**District: Cherwell**

**Application No: 20/00307/DISC**

**Proposal:** Discharge of Condition 12 (Construction Traffic Management Plan) of 19/00607/F

## **Transport Development Control**

Figure 3: Route Restrictions Adjacent to Compound A1

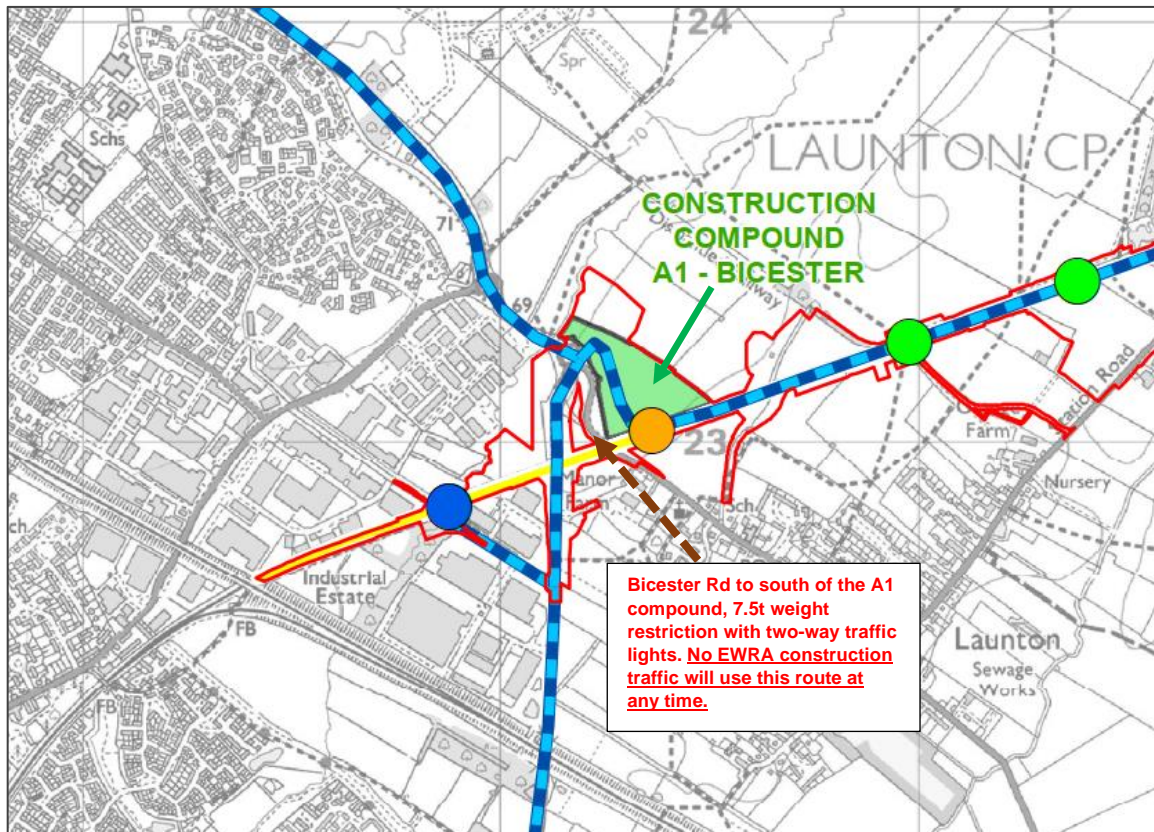
*Figure 3, and para 6.1 Protection of highway assets: It is noted that Figure 3 shows an HGV route heading northwest along the A4421 from the Charbridge Lane roundabout. This does not correspond with the route to the compound described in 3.2, which is accepted. This point should be clarified, as the A4421 to the north must not be used to access this compound. Also, the construction route to compounds in Bucks off the A4421 is understood to be via Junction 10 and the B4100, so I am not clear what traffic would be using this section of the A4421.*

*This section of route gives us cause for concern because bridge assessment records for Launton Sluice (OCC ref. 0081), immediately NW of the roundabout, are poor, and there is a low risk that a weight restriction may need to be imposed.*

**It has been explained that although not the primary route, this is a permitted construction traffic route within the TWAO.**

**EWRA is now aware of this risk and will use appropriate diversion routes should a weight restriction have to be imposed (which is unlikely).**
